PHTV Comments added dated 30/1/17

DATE: 9th December 2016

SUBJECT: LU/234/16/RES - Application for reserved matters relating to access, appearance, landscaping, layout and scale of the previously approved LU/63/11/. This application affects a Public Right of Way.

LOCATION: Fitzalan Link Road, Worthing Rd (A259), East Street, Littlehampton, West Sussex.

| title  | PUBLIC RIGHT OF WAY DIVERSION PLAN |

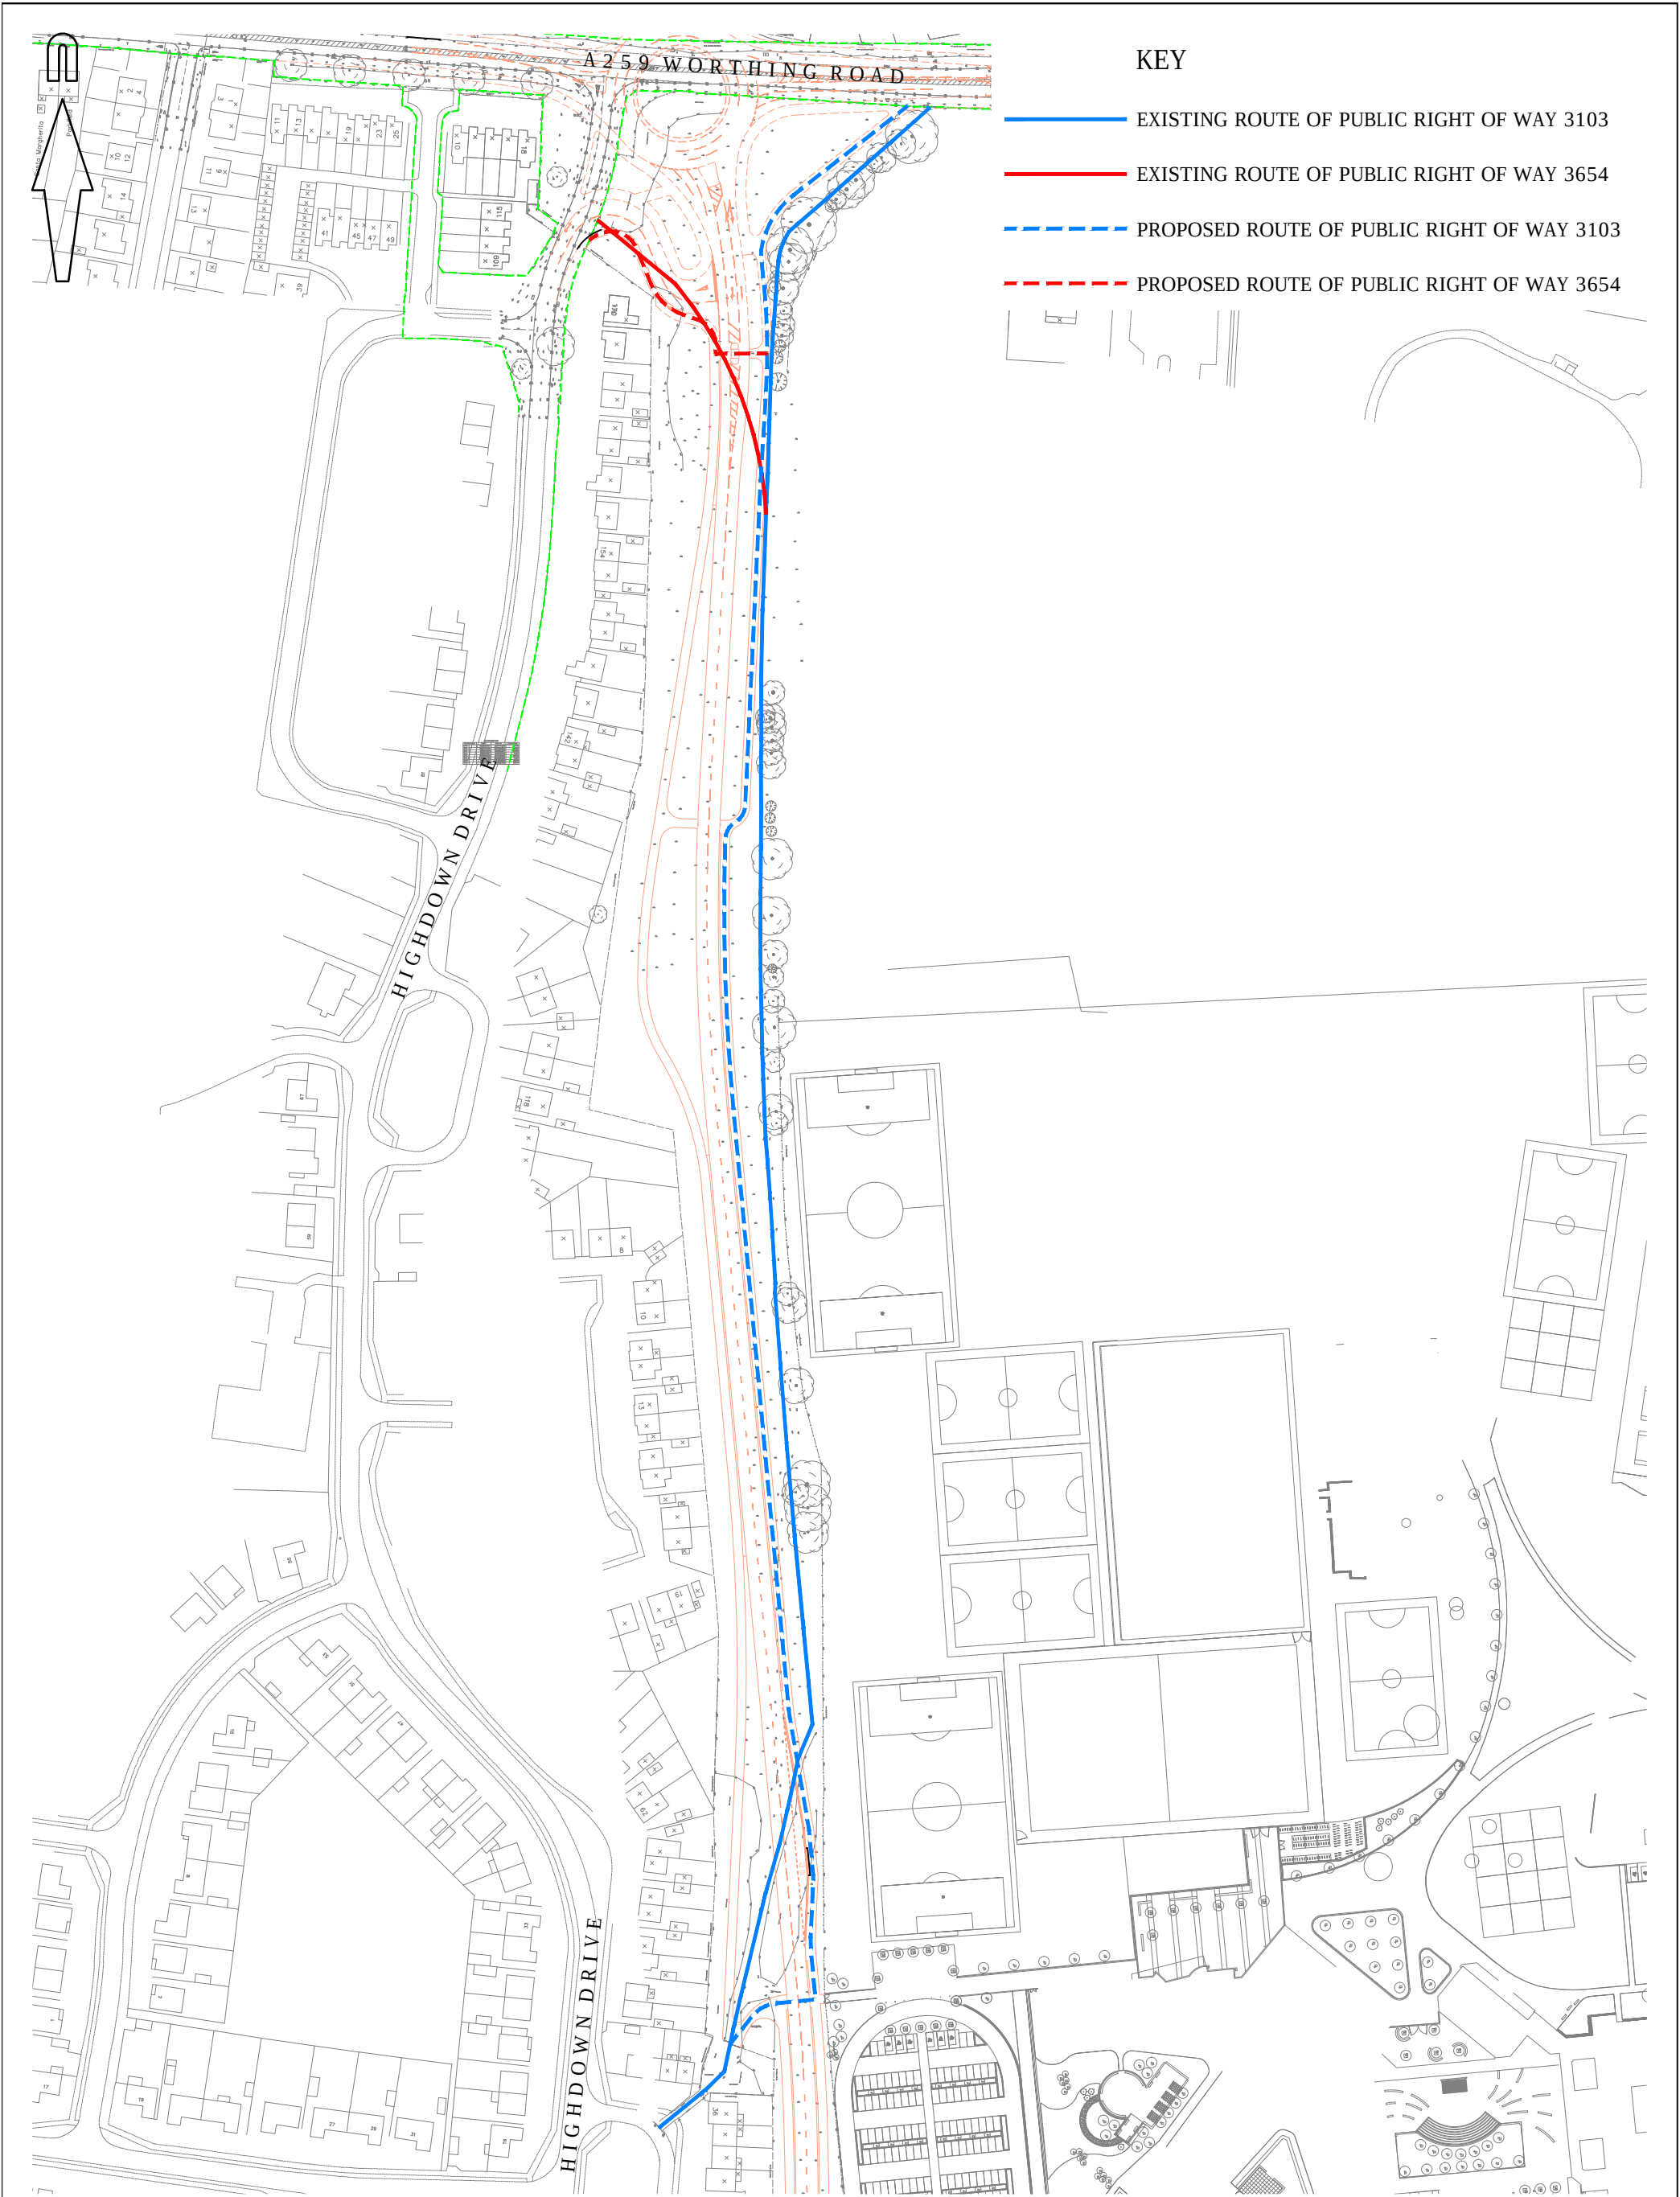
1. Red line boundary – This has implications for PRow connection in south-western corner (north of Academy roundabout) – please demonstrate that an appropriate design can be accommodated and correctly interact with existing PRow connection. As shown, the existing path and the new paths do not appear to tie-in. Also see 3 below. **Further information and alterations required.**

3. Shared footpath/cycleways alongside both sides of the access road – On the western side at the point the PRow joins the scheme, the alignment is very convoluted and may not meet appropriate design standards. Please amend and remove bends etc. This also applies to the 'kink' on the eastern side of the road found further north. Also, because of the increased speed limit along the majority of the road, it is recommended that the footpath/cycleways be set-back from the edge of the carriageway by a minimum of 1.5m wherever possible. Also because of the speed limit, a signal controlled crossing should be provided in this location (Toucan). Any design should be Safety Audited before

With regard to the alignment of the section of shared footpath/cycleway adjacent to the PROW on the western side of the road, the applicant has not provided an adequate alignment. LTN2/08 (cycle infrastructure design) has minimum design radii of 25m for commuter routes and 15m for local access routes. The route running parallel to the new road should be designed as a commuter route, and links off it should be designed as local access routes. Forward visibility requirements are also 25m and 15m respectively. Please show on an amended plan.

Accepted. The full extent of the land required to implement the outline consented scheme has not been made available. As a result, the alignment of the shared footway/cycleway has been altered from that indicated at Outline Consent stage. The geometry of the facility has been revised to provide a more suitable design and continuity of the PRow within the constraints of the site limits. The proposed PRow ties into the existing PRow route at the red line. Please refer to amended drawings PHF-MB-S278-GF-DR-D-210-01 Rev P5 and PHF-MB-S278-GF-DR-D-PROW-01 Rev P3.

Accepted. The full extent of the land required to implement the outline consented scheme has not been made available. As a result, the alignment of the shared footway/cycleway has been altered from that indicated at Outline Consent stage. The geometry of the facility on the western side has been revised to provide a more suitable design and continuity of the PROW within the constraints of the site limits. The proposed PROW ties into the existing PROW route at the red line. Please refer to amended drawings PHF-MB-S278-GF-DR-D-210-01 Rev P5 and PHF-MB-S278-GF-DR-D-PROW-01 Rev P3.

The geometry of the eastern facility has been amended to provide a more suitable design as requested. Please refer to amended drawings PHF-MB-S278-GF-DR-D-210-02 Rev P5 and PHF-MB-S278-GF-DR-D-PROW-01 Rev P3.
